**From:** Hannah Keyte [REDACTED]  
**Sent:** 25 June 2025 09:43  
**To:** Kathryn Welch <Kathryn.Welch@arun.gov.uk>  
**Subject:** RE: CM/12/25/PL - Old Butcher's Flat

**From:** Hannah Keyte [REDACTED]  
**Sent:** 21 May 2025 11:38  
**To:** Kathryn Welch <[Kathryn.Welch@arun.gov.uk](mailto:Kathryn.Welch@arun.gov.uk)>  
**Cc:** Andrew Watson [REDACTED]  
**Subject:** CM/12/25/PL - Old Butcher's Flat

PROPOSED ELEVATIONS
 1:100 @ A3

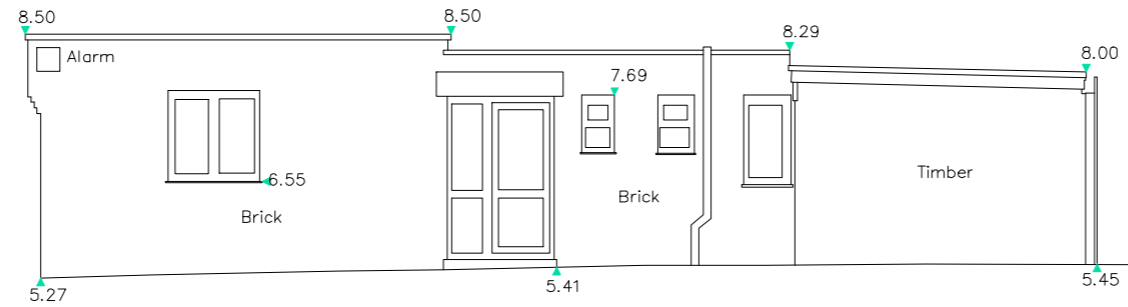
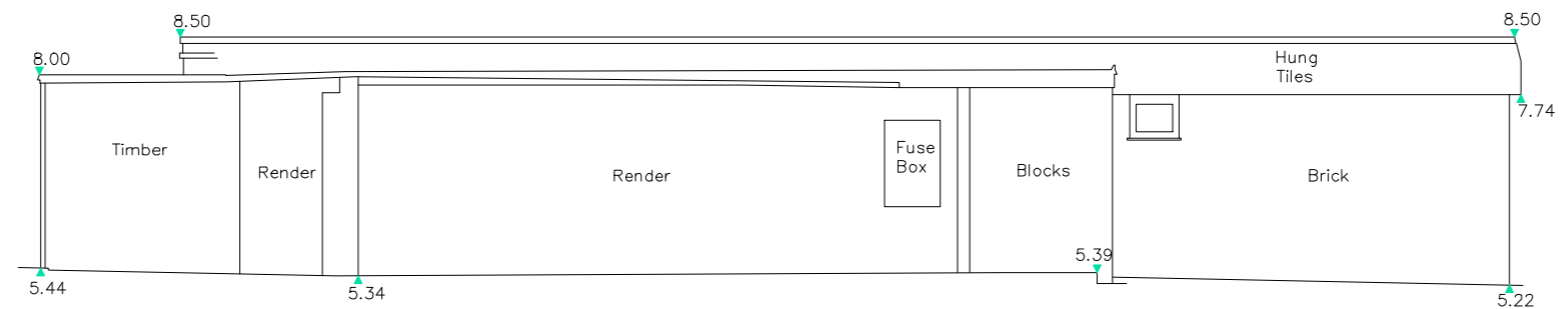
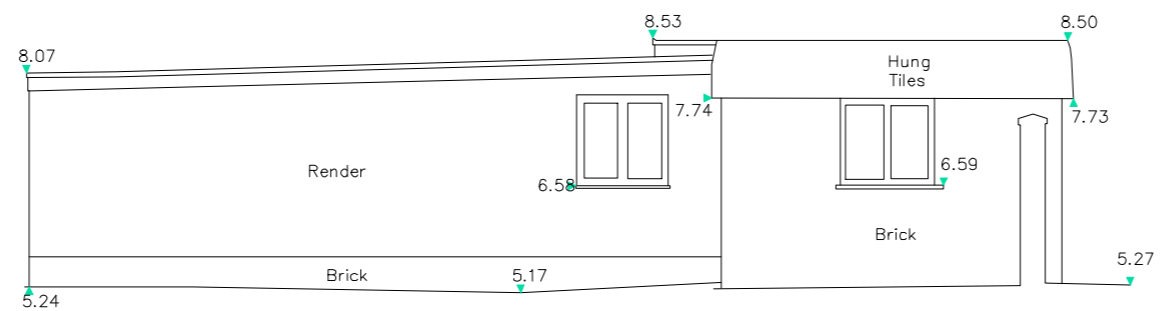
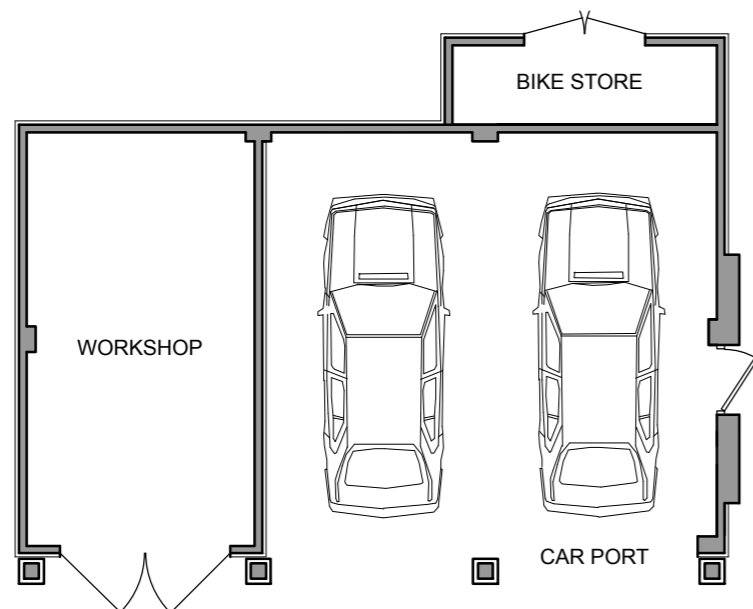
In the meantime, could you please review the submitted comments, particularly those from our Conservation Officer, who has raised concerns about the overall appearance of the building? I've also noticed some inconsistencies in the plans—especially regarding the roof structure—and would advise a thorough review to identify and address any discrepancies.

- Mathematical Tile Hanging omitted and replaced with a less complex traditional tile hanging.
- Inconsistencies to the roof structure now corrected.

Drainage Plan 2 11th July 2025

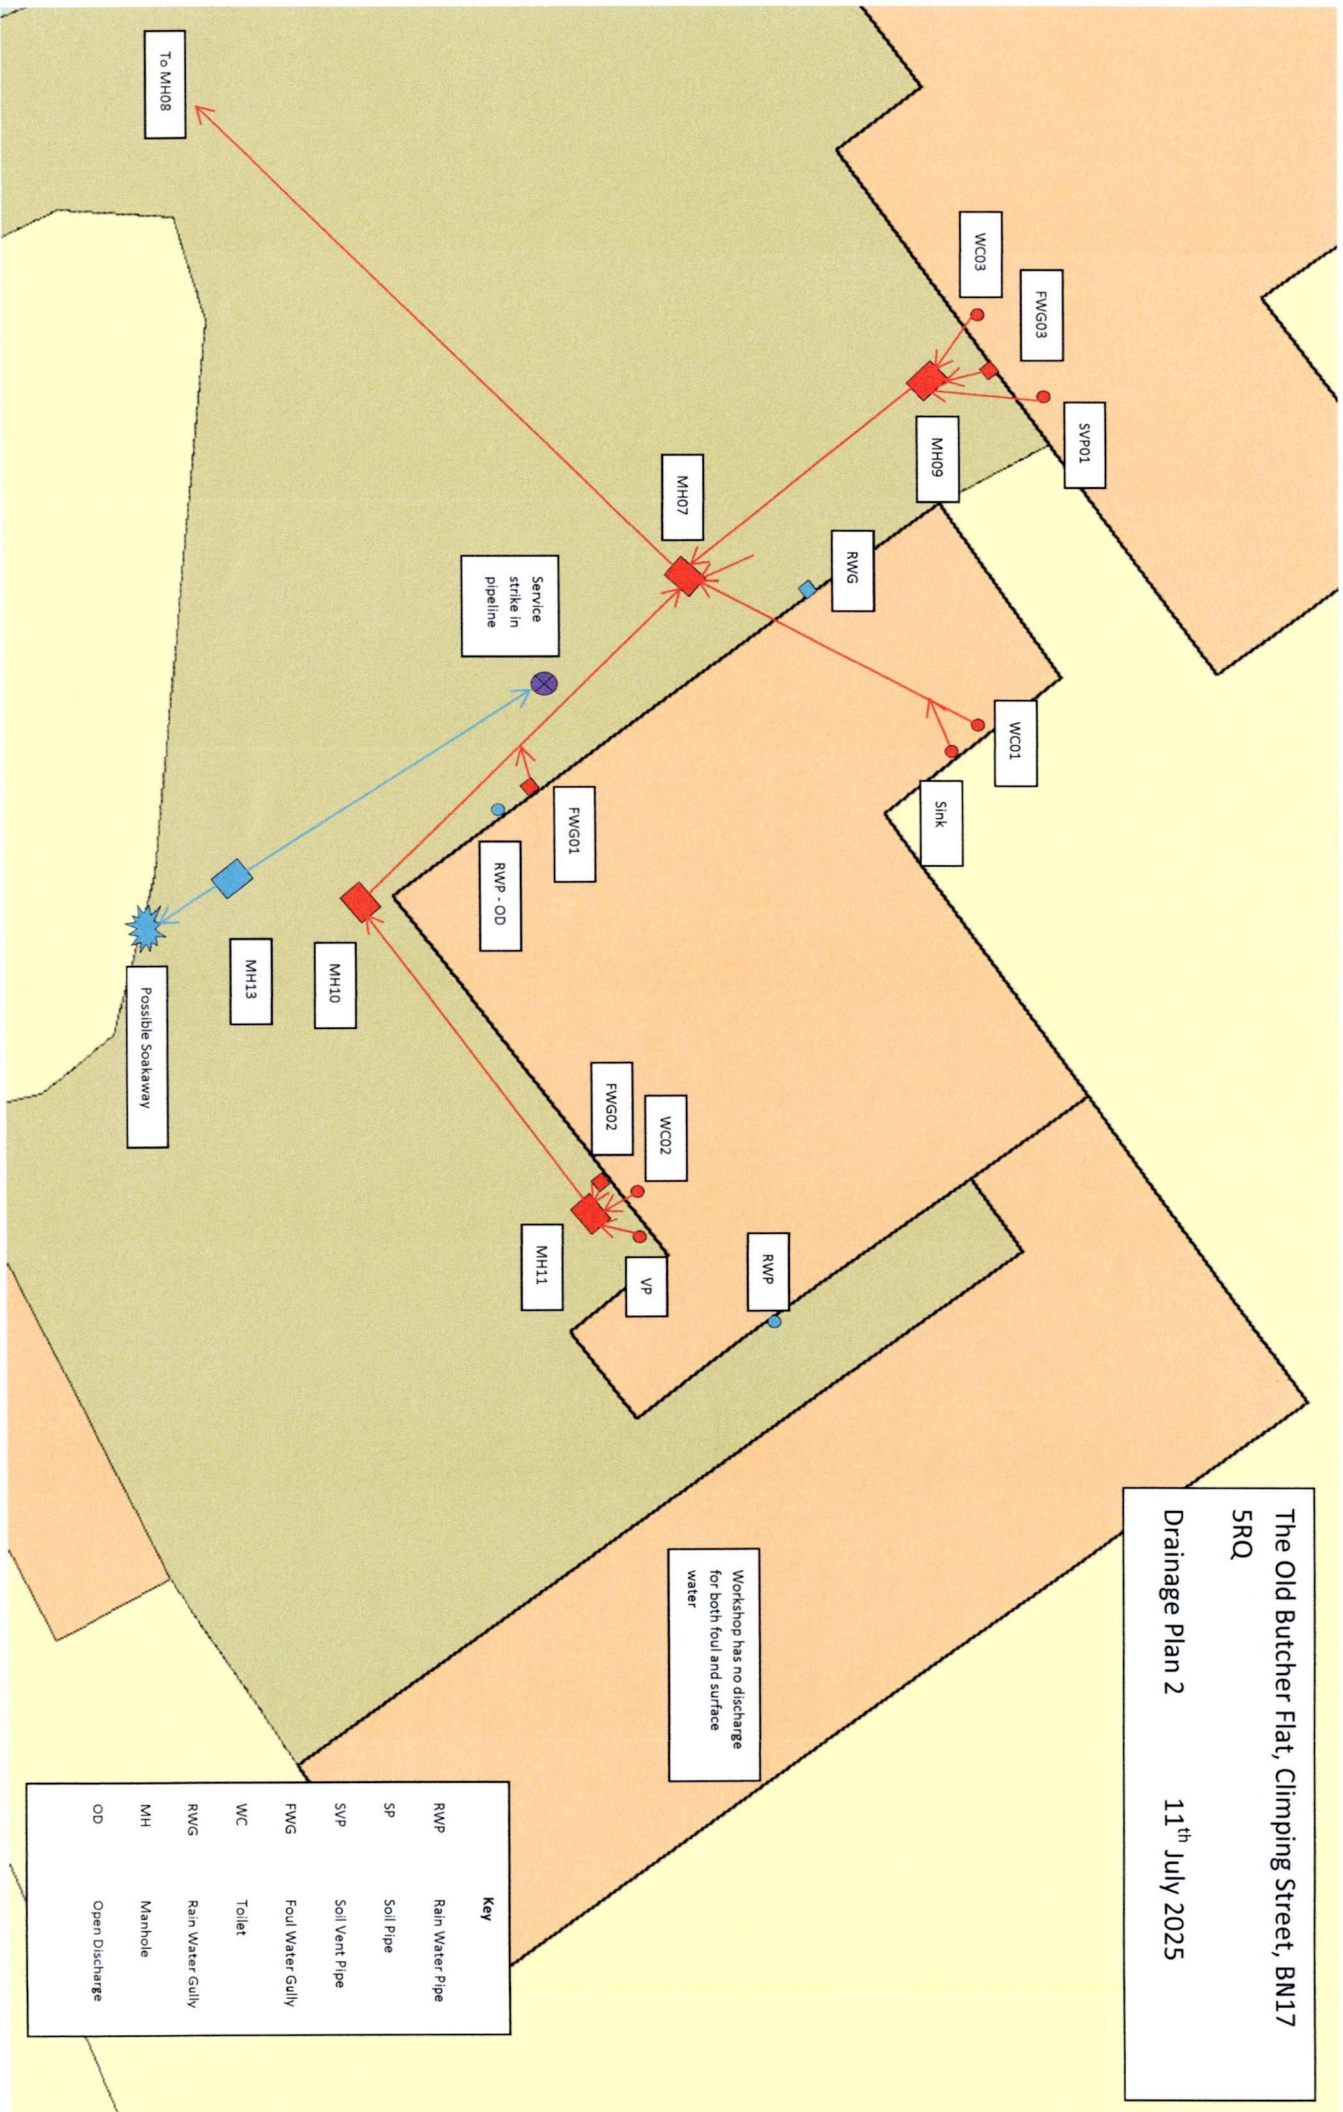
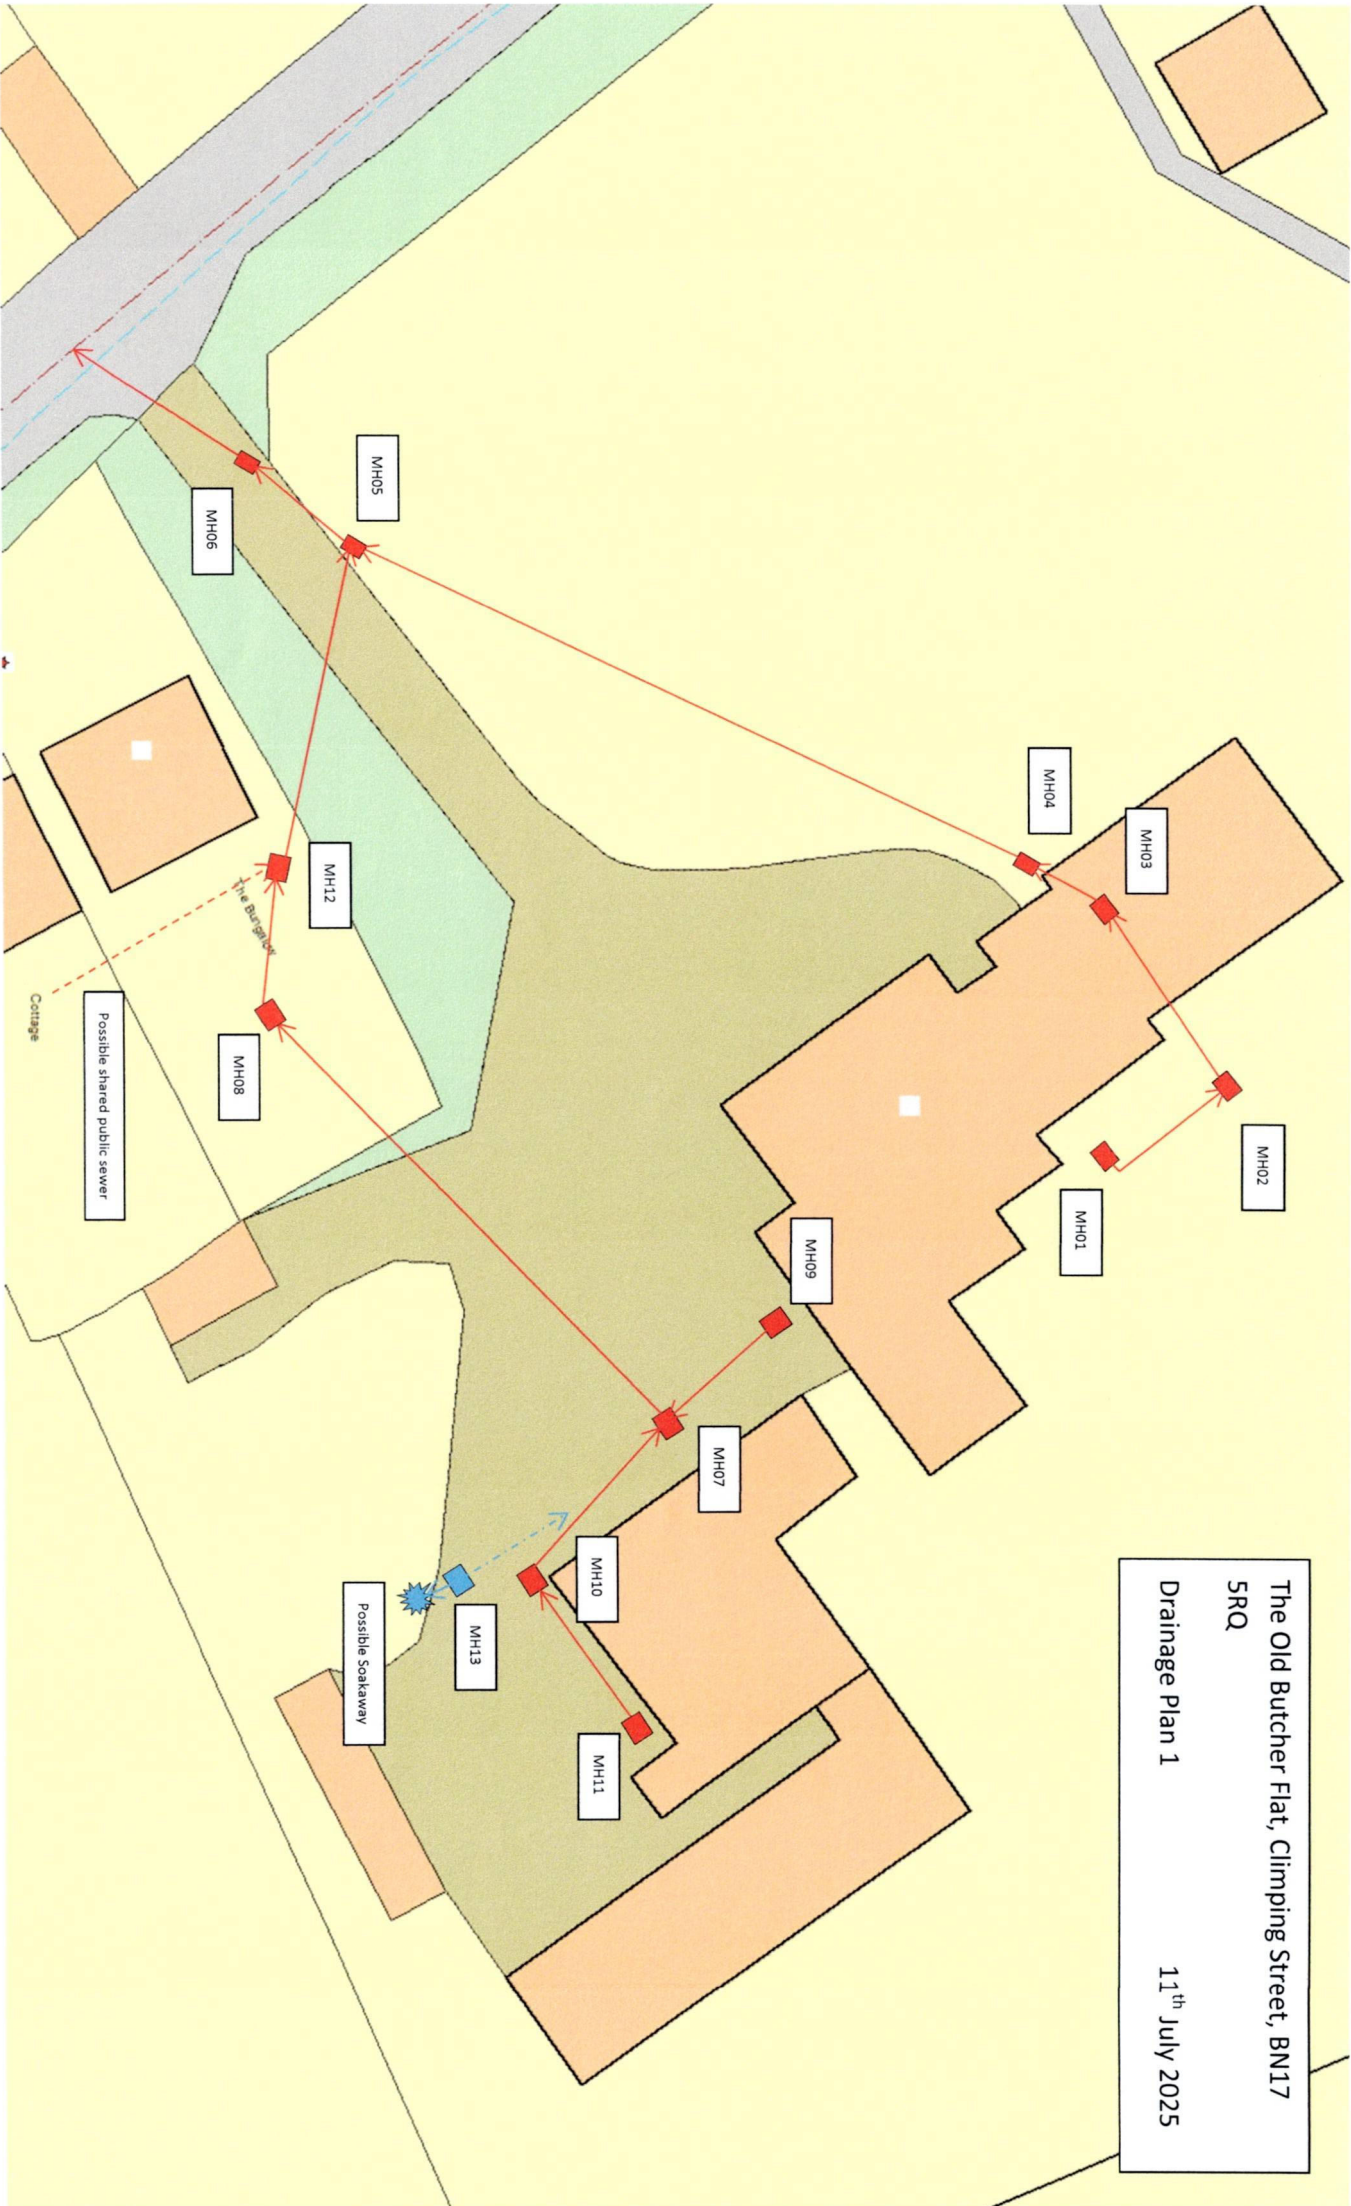
On that note, I noticed that the drainage strategy does not include an existing drainage layout, groundwater monitoring, or infiltration testing. Have these been undertaken yet? I'm concerned that without this information, it may result in an objection from our Engineers.
